Application No: LU/55/22/L

Site Address: The Flintstone Centre East Street Littlehampton BN17 6AW

Description of works: Listed building consent for the installation of 3000mm high welded mesh fencing and associated single leaf gate along a section of the northern boundary line and along the rear elevation, Ornamental fencing and associated gates to be installed, located adjacent to the existing southern side entrance to the building, as well as the installation of 3000mm high welded mesh fence encapsulating the existing boiler room to the rear of the building, demolition of existing side secondary entrance including existing ramped access and associated fittings. Repairs to the section of wall affected by the removal of the entrance.

Thank you for your internet representation made on 8th March 2022 which has been recorded as an objection with the comments as follows:

EUROGUARD® REGULAR

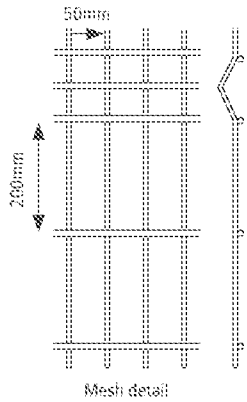
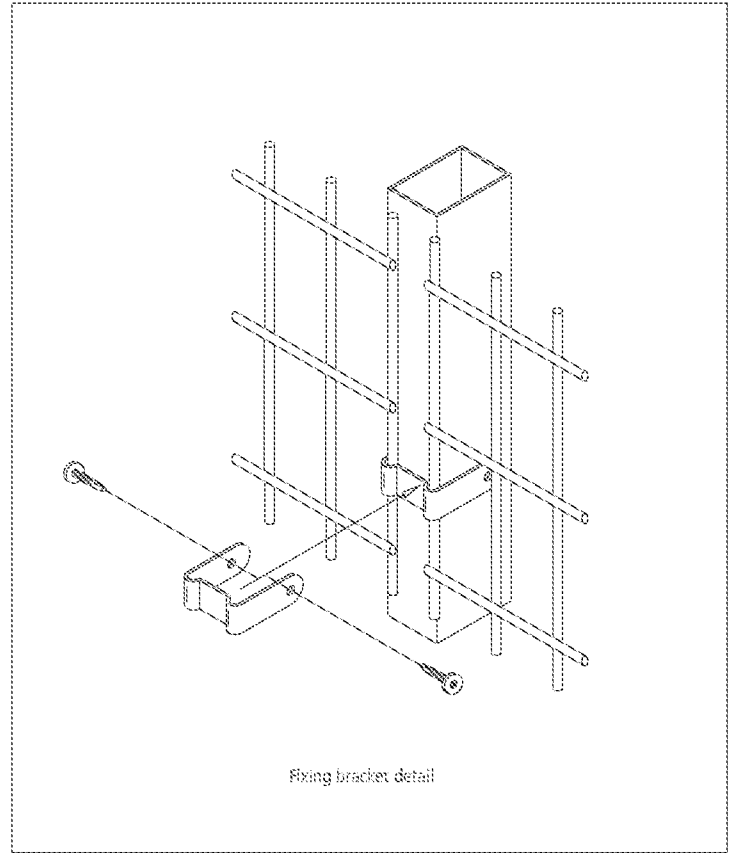
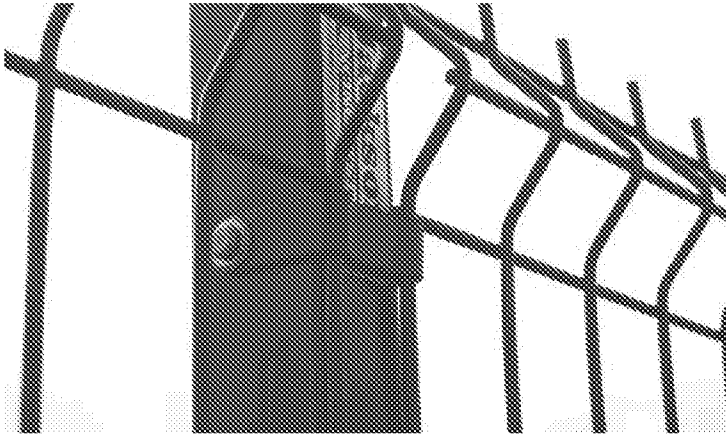
The planned Euroguard Weld mesh fencing is totally inappropriate for the site at the rear of the Flintstone Centre. We at The Old Dairy Farm development will be looking straight at the prison like fence only approx 3 metres from our property, which is unacceptable. The fence should be as originally discussed (planned?) & an ornamental heritage style fence as befitting the conservation area be installed. We support & agree all more detailed comments supplied by our Dairy Farm neighbours.
